Feedback on draft report from CCC

Feedback on draft report from ATOAC

Re: Comments Regarding the Draft Report for the Aboriginal Heritage Impact Assessment for the Hexham Relief Roads Project

Figure 5.3 Locations of previous investigations within the study area.

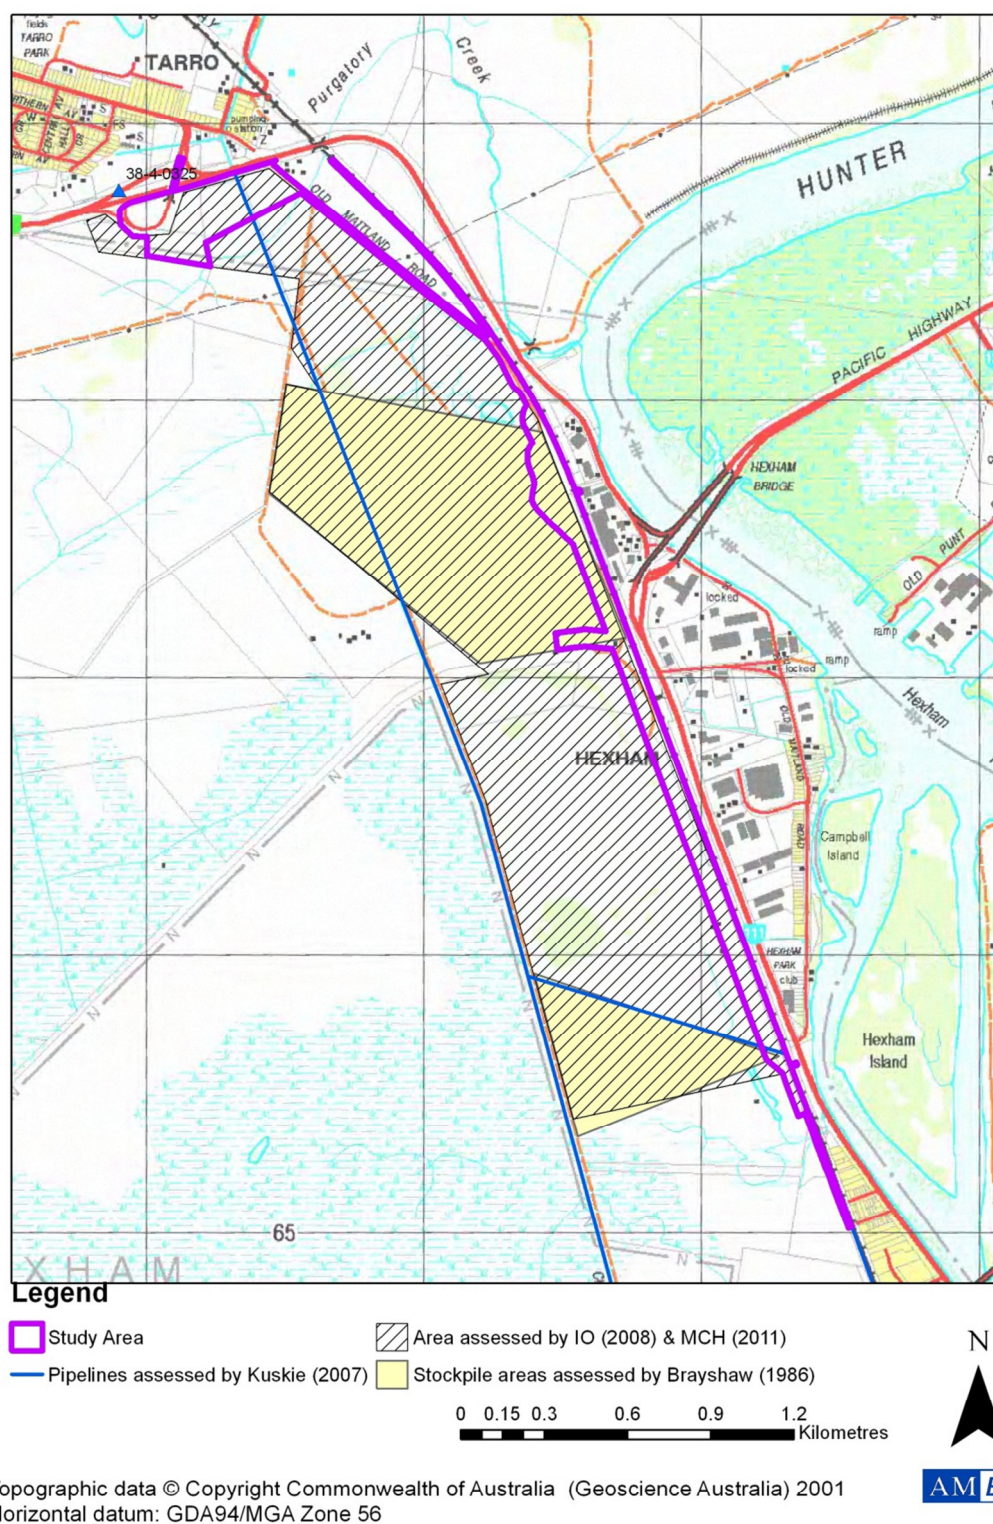
Page 23 - 27, With reference to the previous Archaeological investigations, we are concerned that the majority of the references given are more than 10 years old. Additionally, we believe that there is a need for further analytical research concerning the Hunter region and submit this request to be a part of the outcomes of this assessment, including: a holistic approach to Aboriginal Archaeological research; identify geological history of the Awabakal region; identifying the Awabakal ethos; statements regarding perspectives and diversity associated to the Awabakal Aboriginal Cultural Heritage.

Figure 8.2 Location of sites/PADs to be impacted by the projects (with "Cultural PAD" redefined based on disturbance).

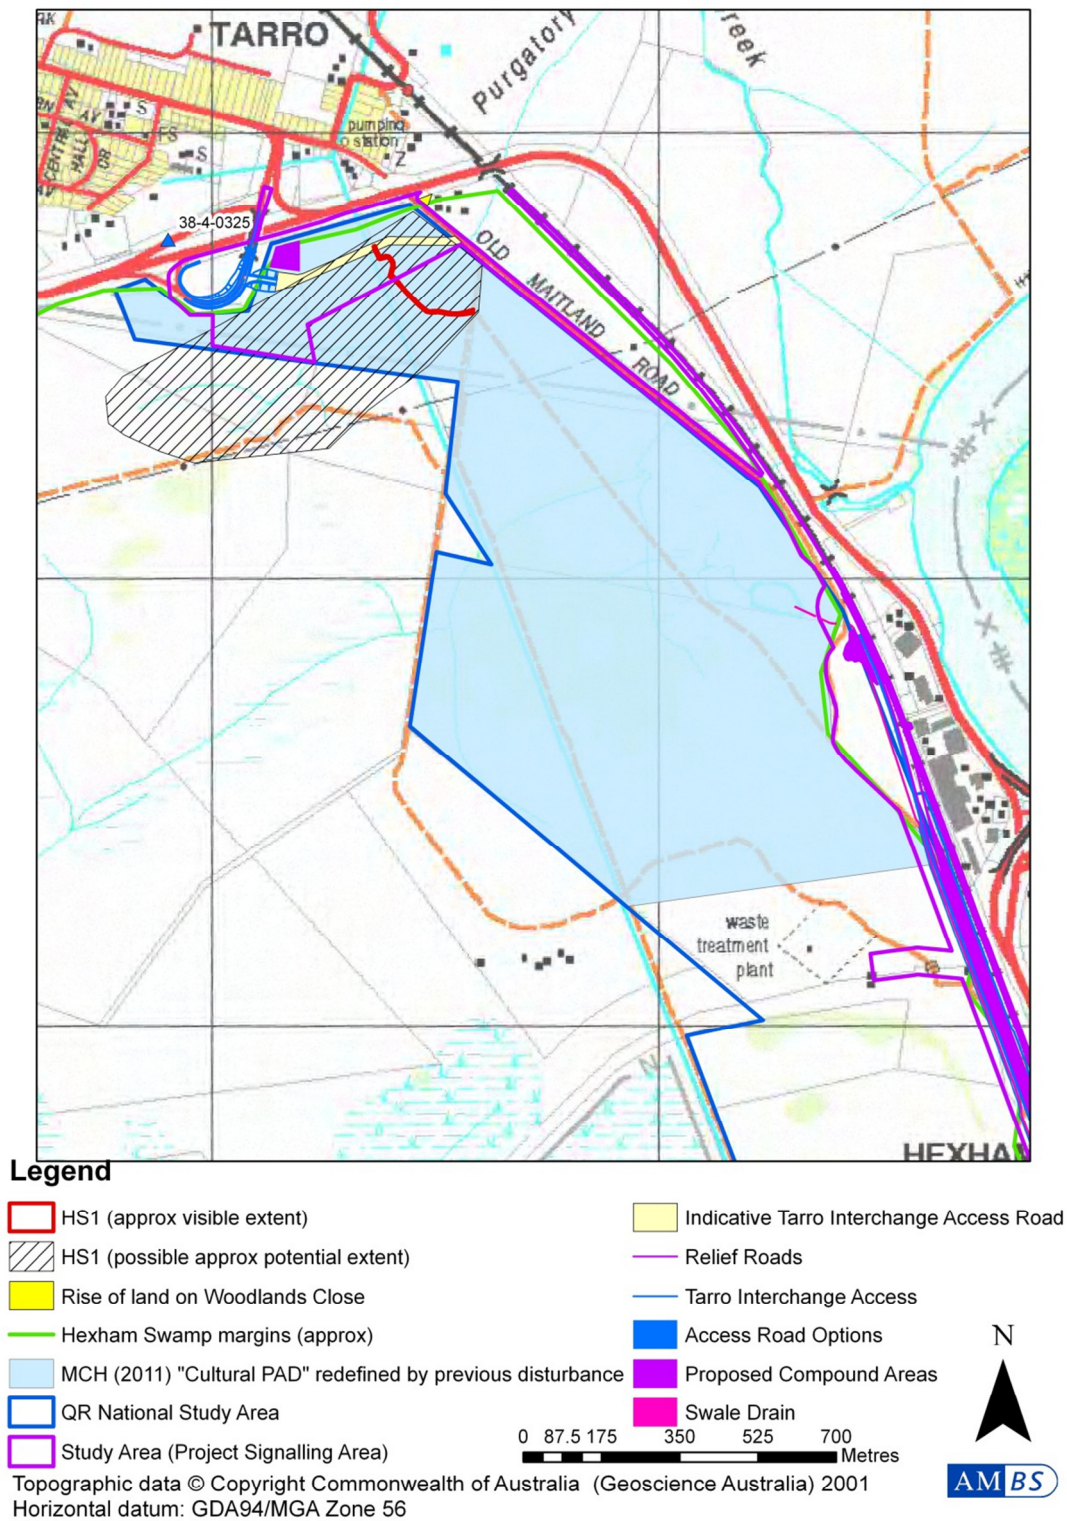
Page 54, 9.1.3, With regard to the **Recommendation 3** we agree that...*“an archaeological test and salvage excavation should be undertaken in any section of the cultural PAD proposed to be impacted”*.

Additionally, we identify the need that adequate time is allowed for the archaeological test and salvage excavation program, and that this needs to be undertaken prior to any earthworks.
